DRB Application No.: 03-01230 (SBP)  
Project Name: PTI ELEC. CONTRACTORS  
Agent: Miller & Associates

**CITY OF ALBUQUERQUE  
PLANNING DEPARTMENT  
Development Review Board  
July 30, 2003 Comments**

**Project # 1002832**

**RE: PTI Electrical Contractors**

UNIMPROVED
SITE PLAN 1" = 20"

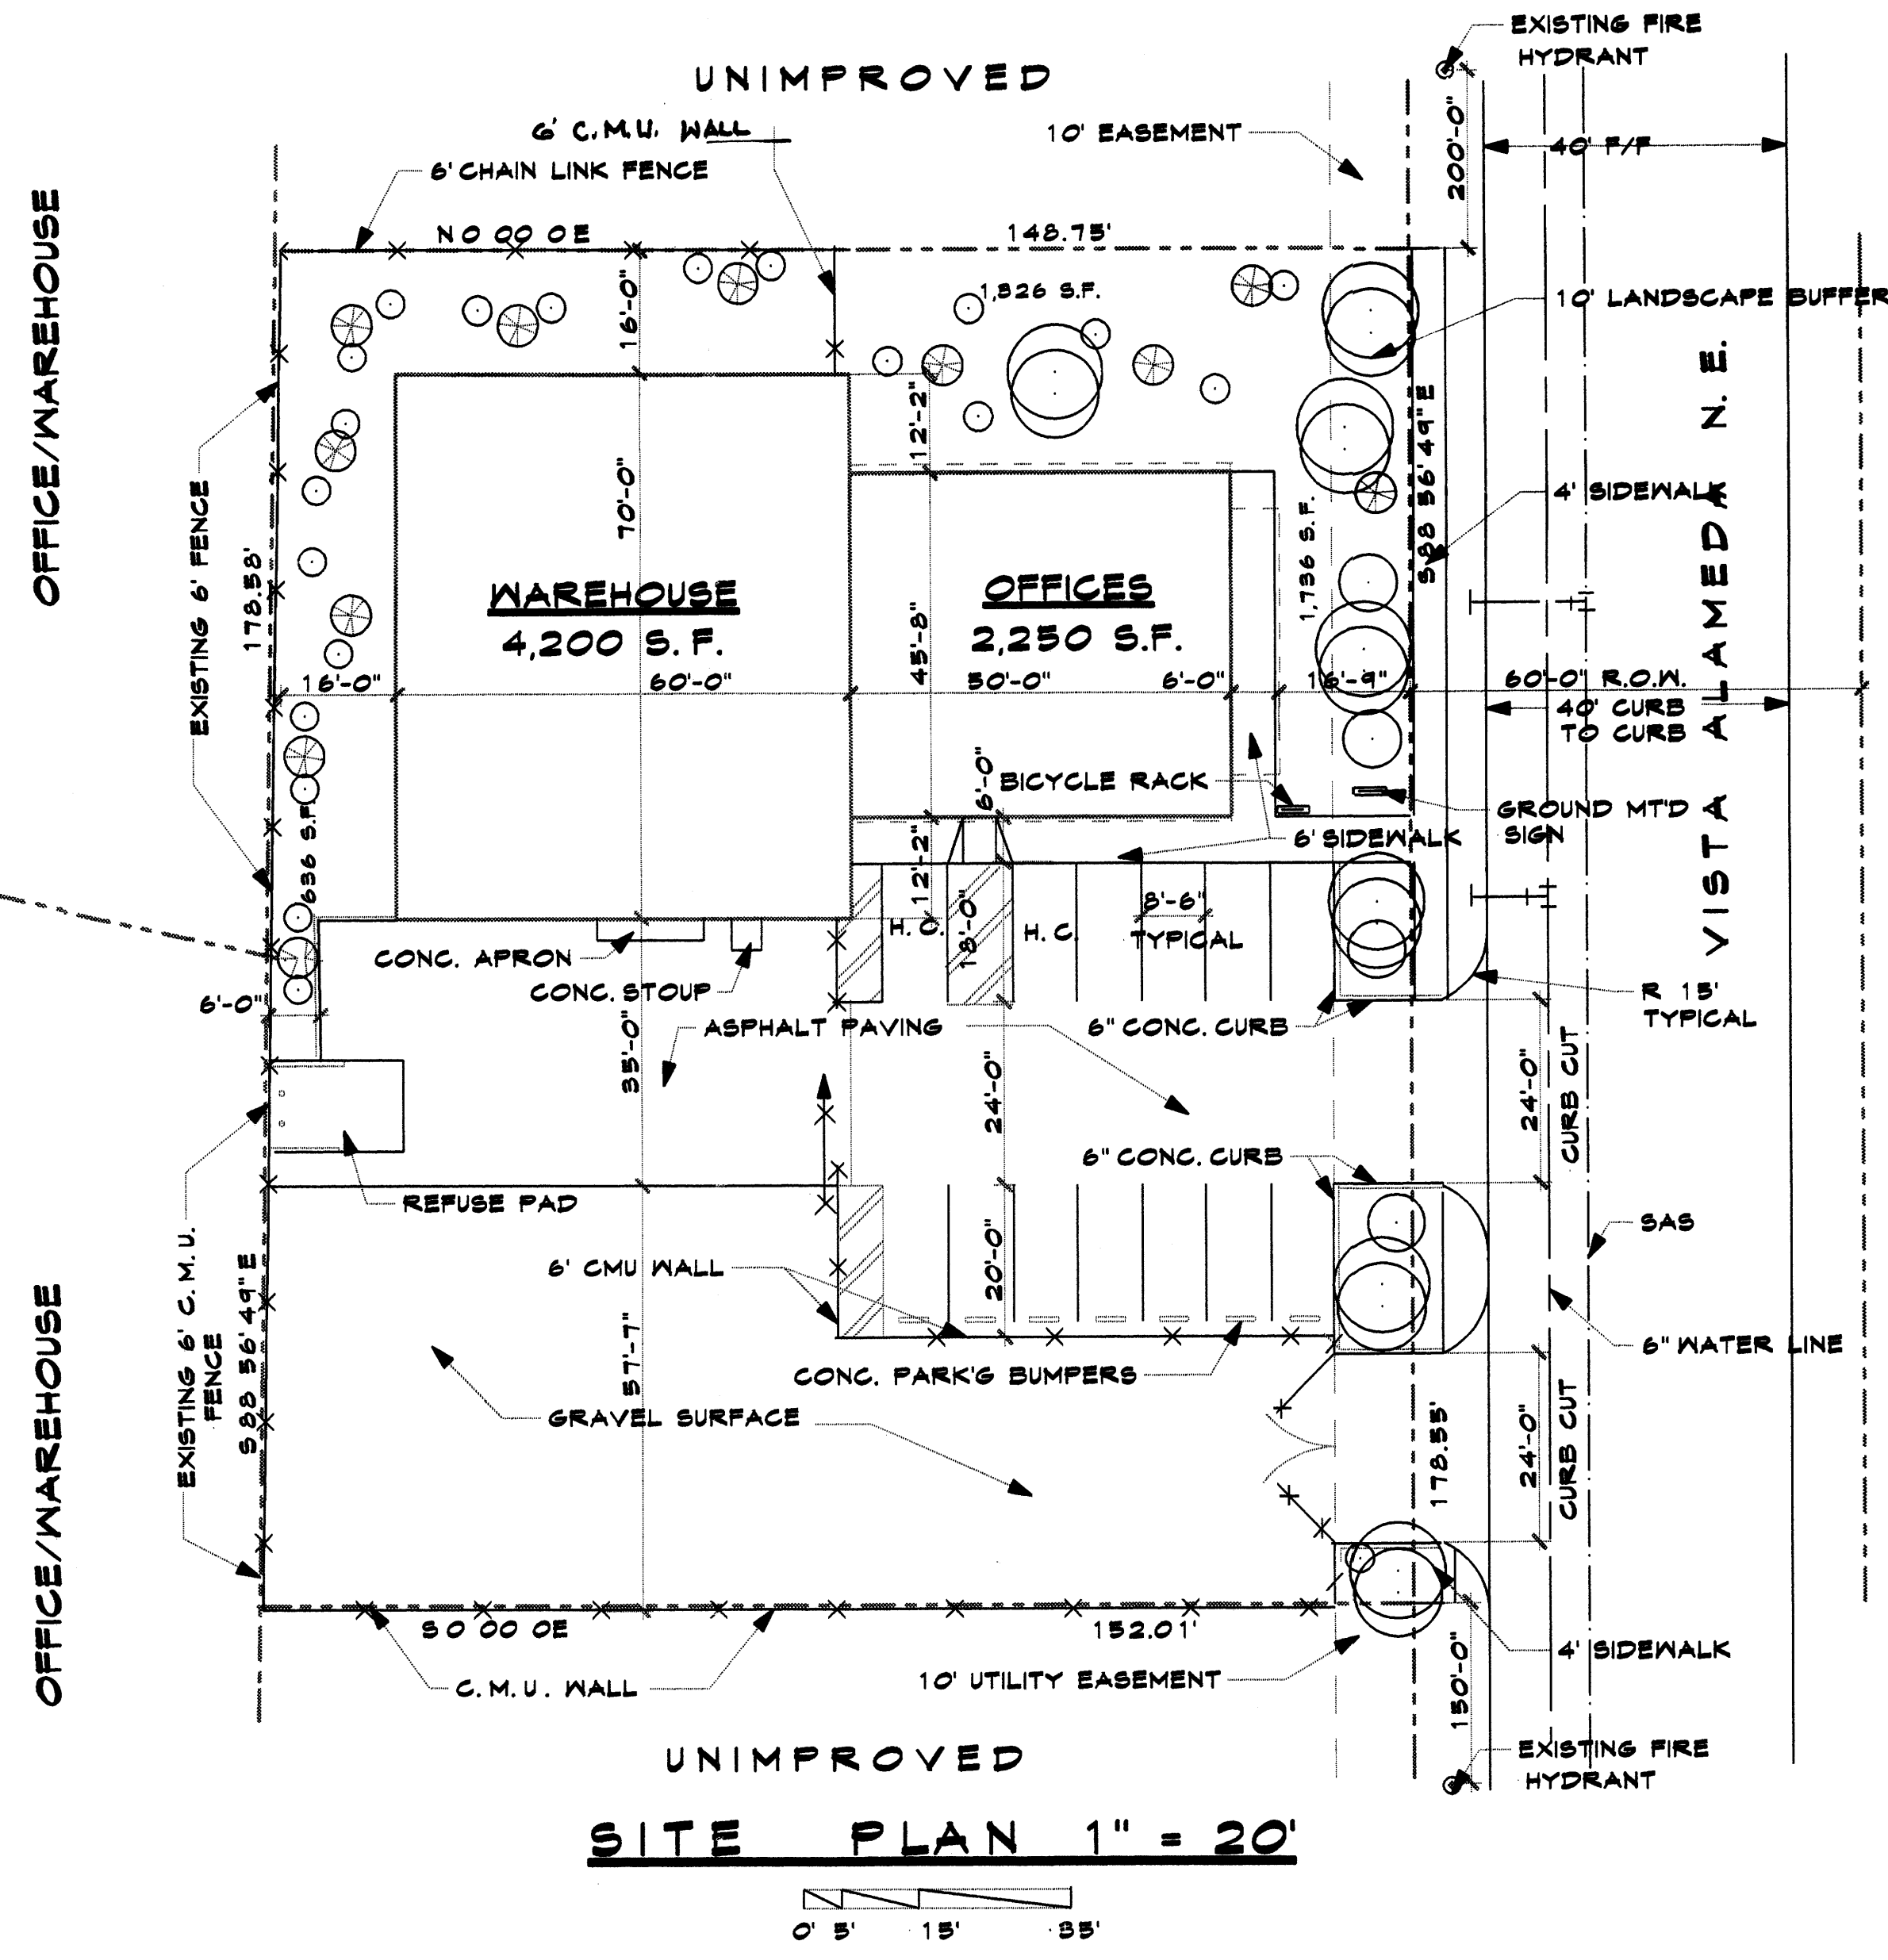
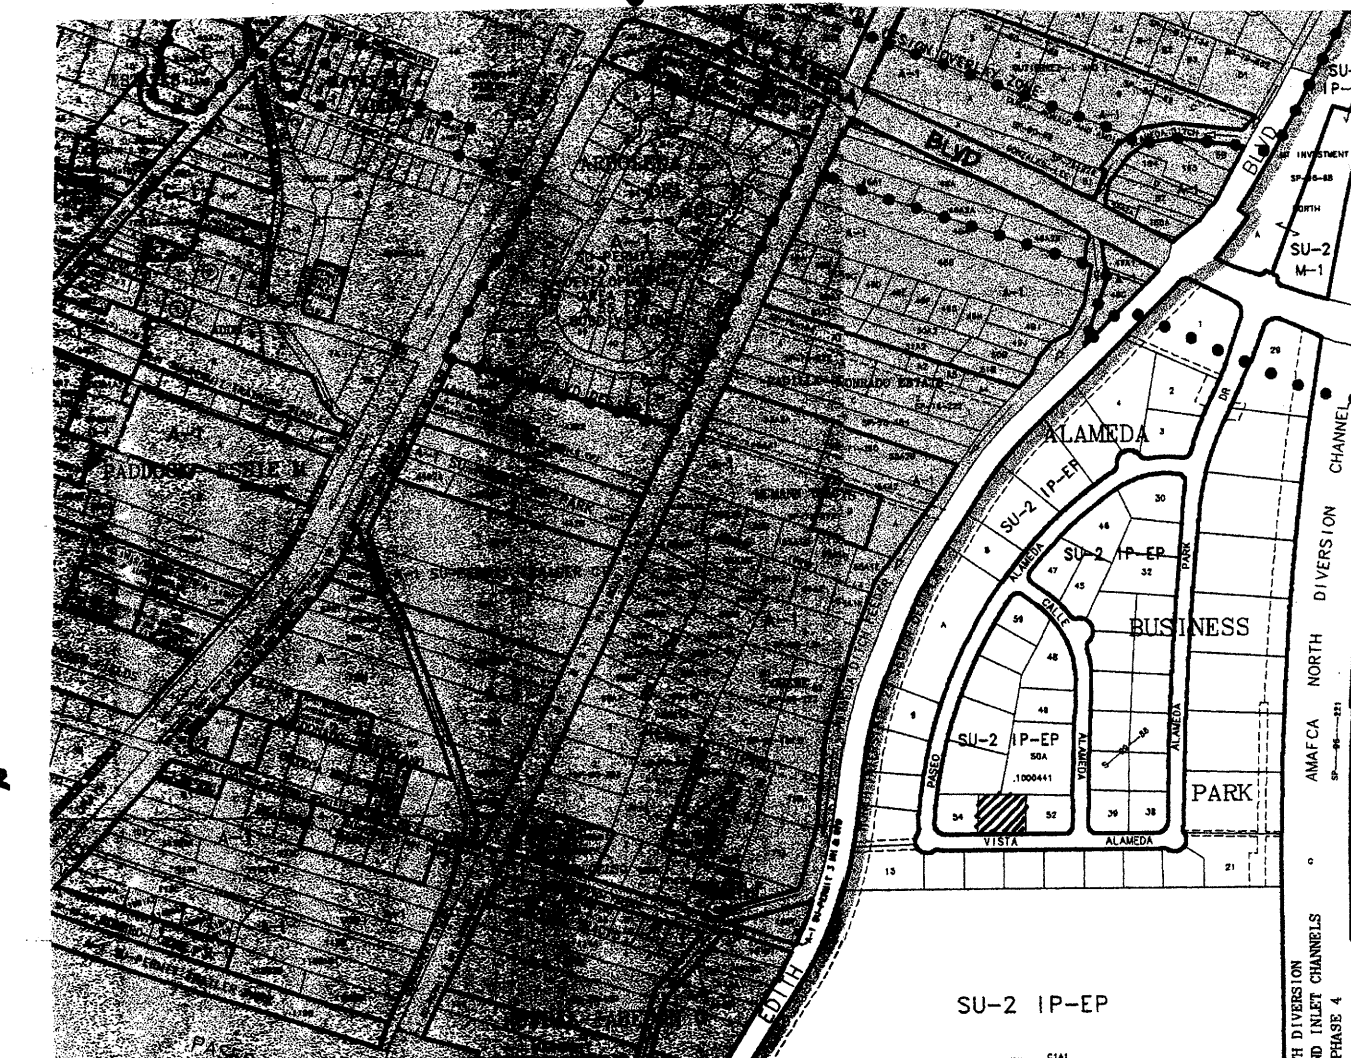
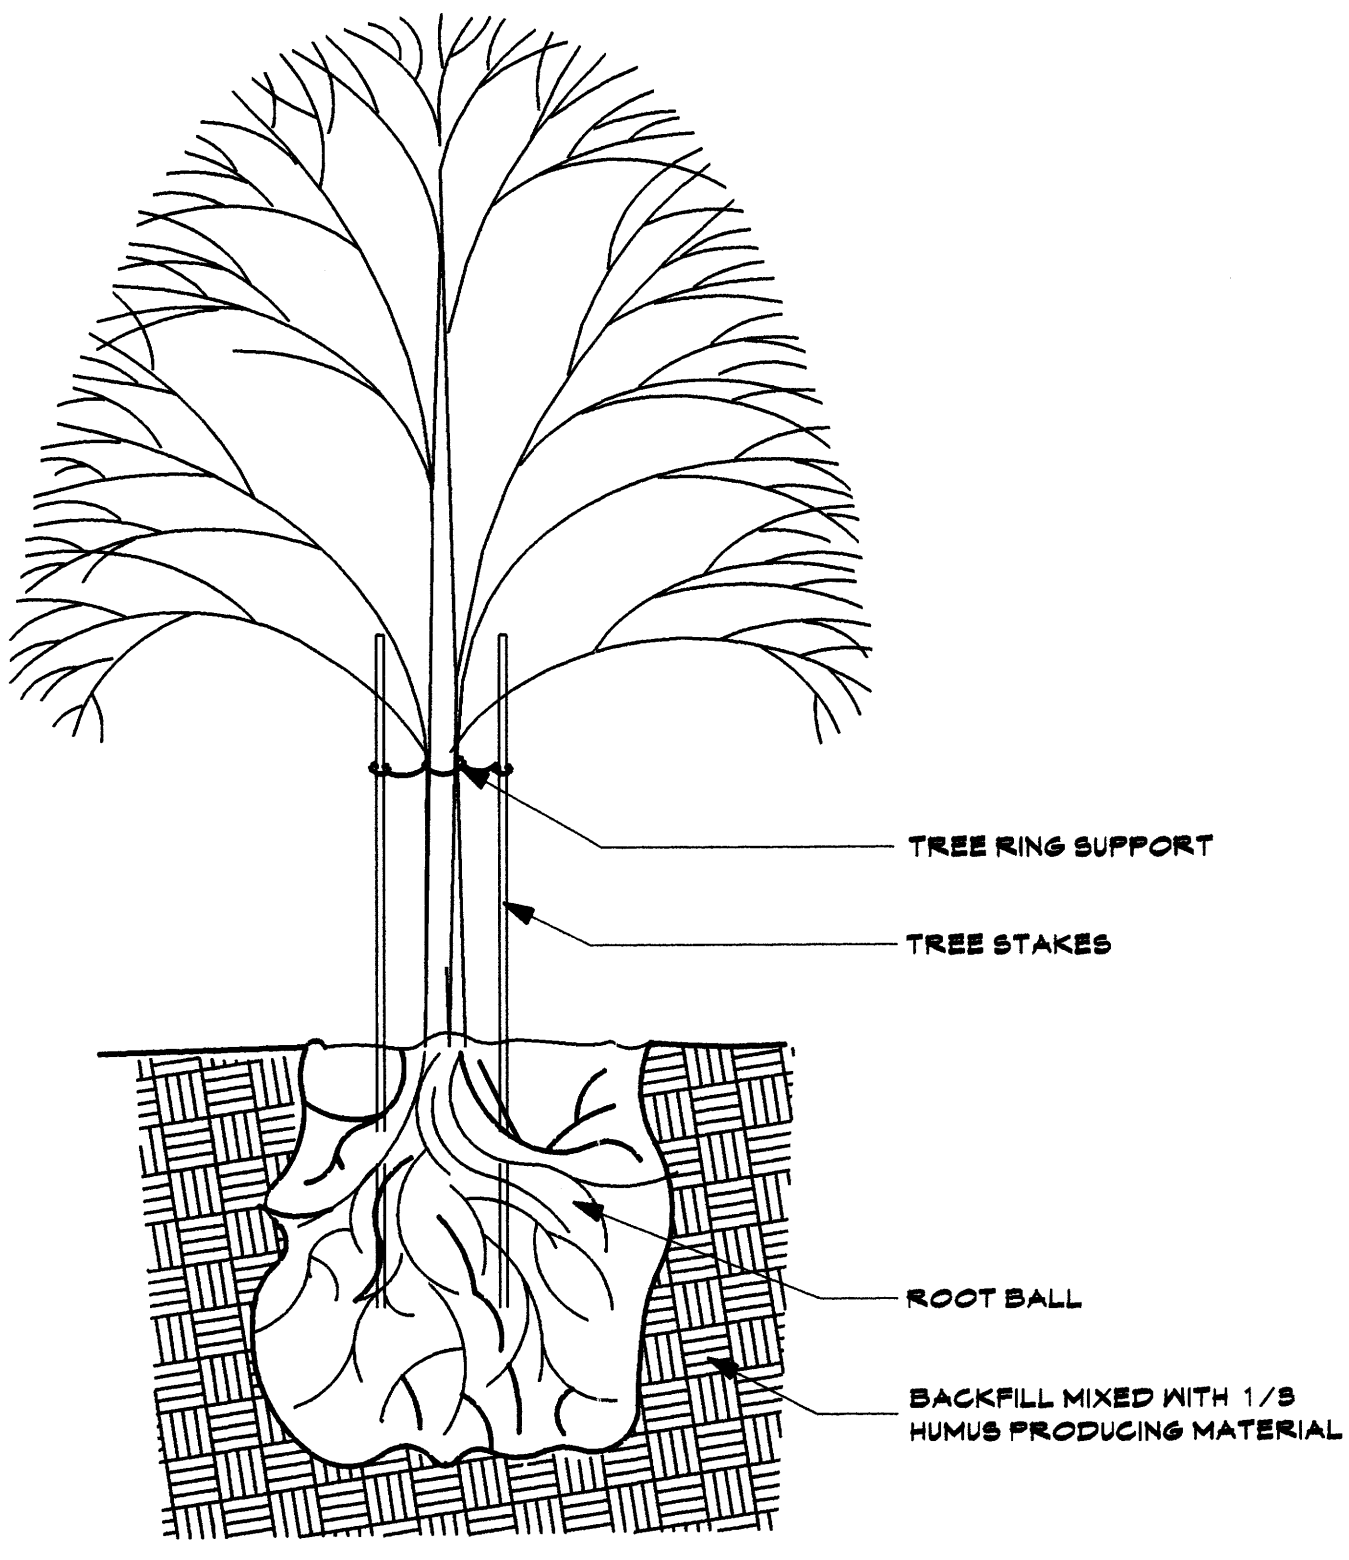
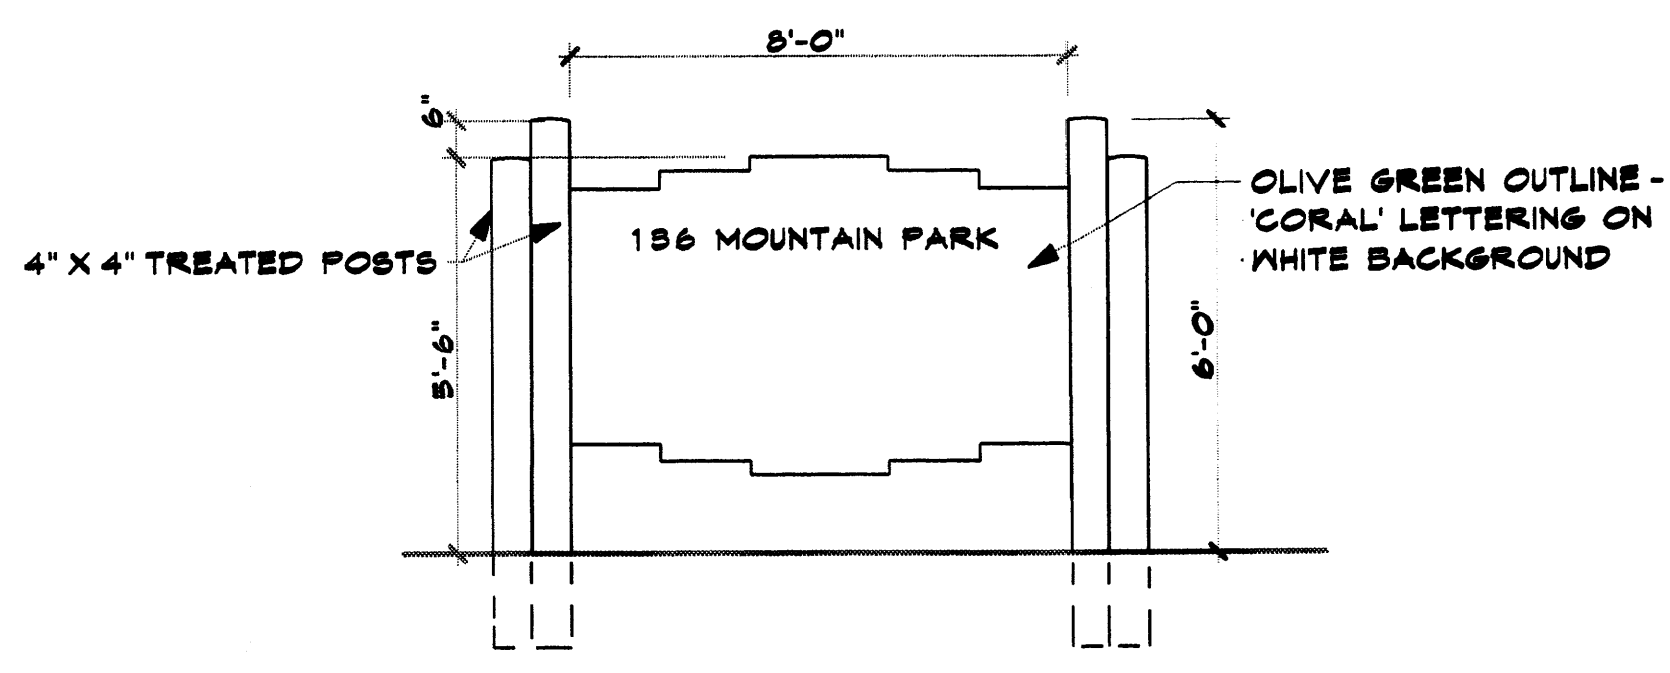
The site plan sheet title should read "Site Development Plan for Building Permit". The Project & Application #s should be filled in on the original mylar before DRB signs off. The signature line for Traffic Engineering should have the word "Traffic" correctly spelled on the original mylar.

Page 53 of the North I25 Sector Plan, one of the 2 plans to which this site plan must conform, has specific language for loading areas. With a warehouse use, we assume there is a loading area. It is not indicated on the site plan. These Special Screening Standards must be met with language and/or location as appropriate on the Site Plan. The Alameda Business Park Master Development Plan has similar language.

Page 54 of the North I 25 Sector Plan requires a standard landscaping buffer of at least 6 feet wide along the side and rear property lines of industrial development. Your site plan is lacking these buffers in some areas.

Some parking spaces are more than 50' from a tree. See page 55 of the North I25 Sector Plan and the Alameda Business Park Master Plan.

The free standing sign cannot exceed 75 square feet since the property abuts a local street. See Section 14-16-2-19,A (23) (c) (a) of the Zoning Code. The overall sign & mount height is fine as shown.

The site plan should also contain the statement found in the Master Plan relative to mechanical equipment on roofs:

“Mechanical equipment on roofs is to be screened from public view as much as practical. Roof equipment screens are to be at least as high as the highest part of the equipment. Roof screens are to be architecturally compatible with the building.”

JOB NO. 0325
DATE Jul '08
REVISION
DRAWN BY JWM
CHECKED BY
SHEET TITLE LANDSCAPE PLAN, NOTES & DETAILS
MILLER AND ASSOCIATES ARCHITECTS PLANNERS 5220 SECOND STREET N.W. ALBUQUERQUE, NEW MEXICO 8057 348-1912
JOB TITLE OFFICE/WAREHOUSE CONTRACTOR PTE ELECTRICAL CONTRACTOR ALBUQUERQUE, NEW MEXICO

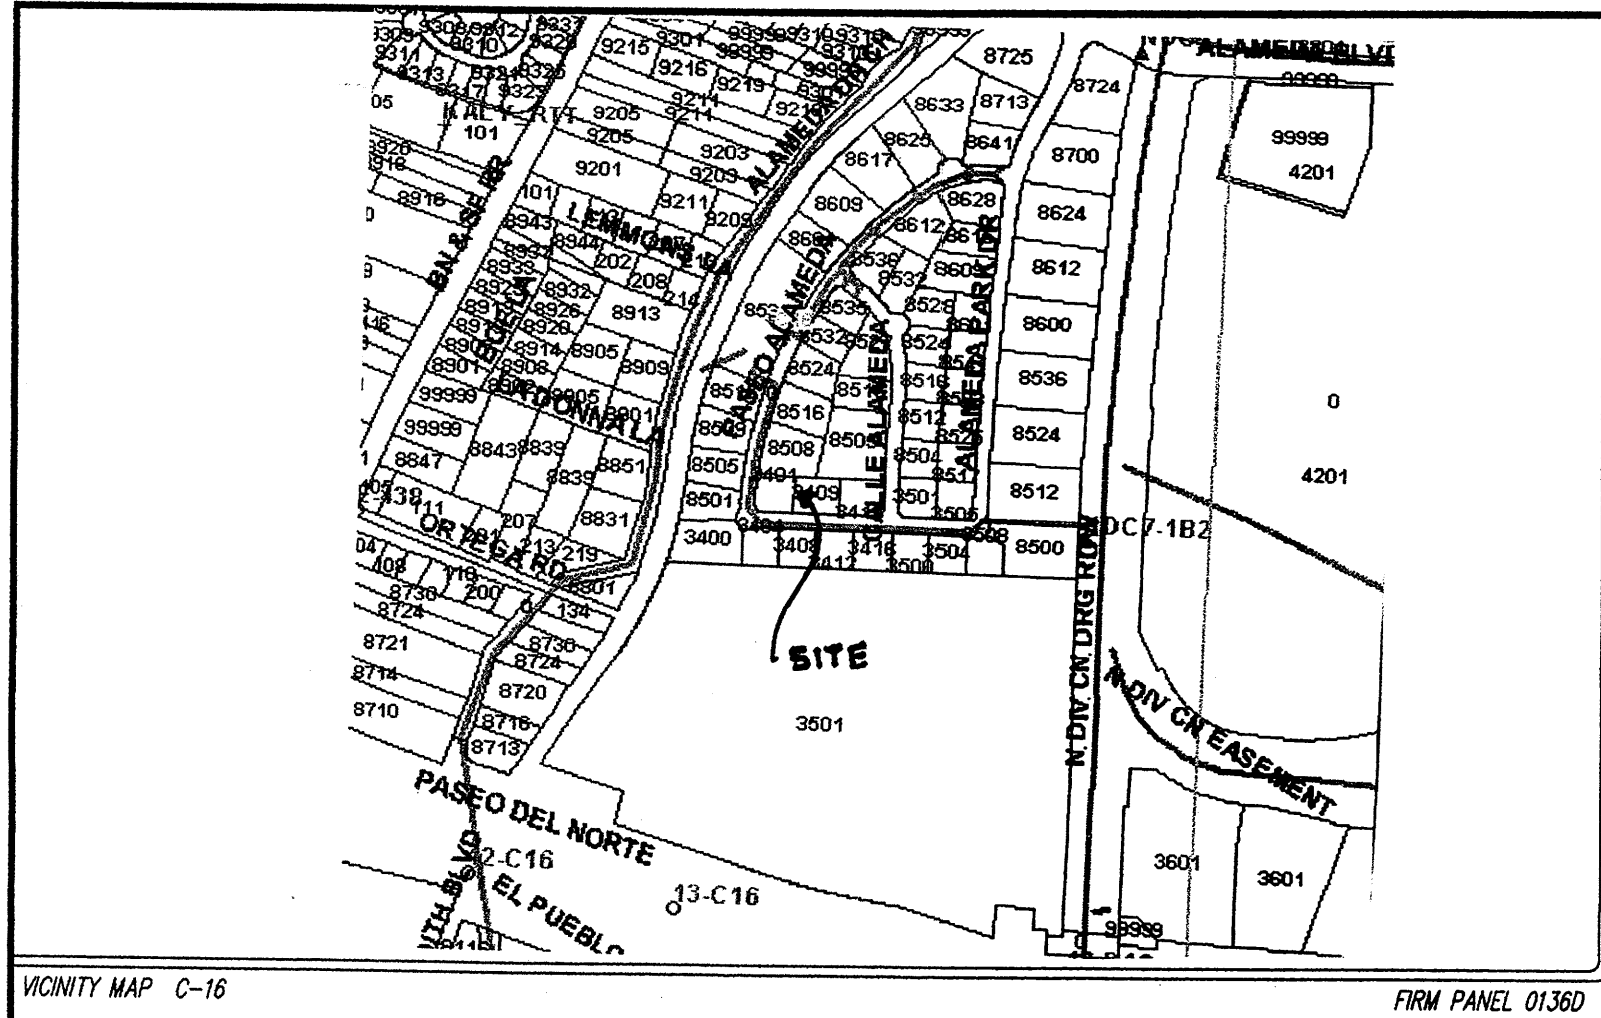
Notes 11, 12 & 13 of the Landscape Development Notes in the Alameda Business Park Master Plan should be a note on your Landscaping Plan as well.

The trees, shrubs, etc noted on your landscaping plan must have the H,M or L water use designation as well.
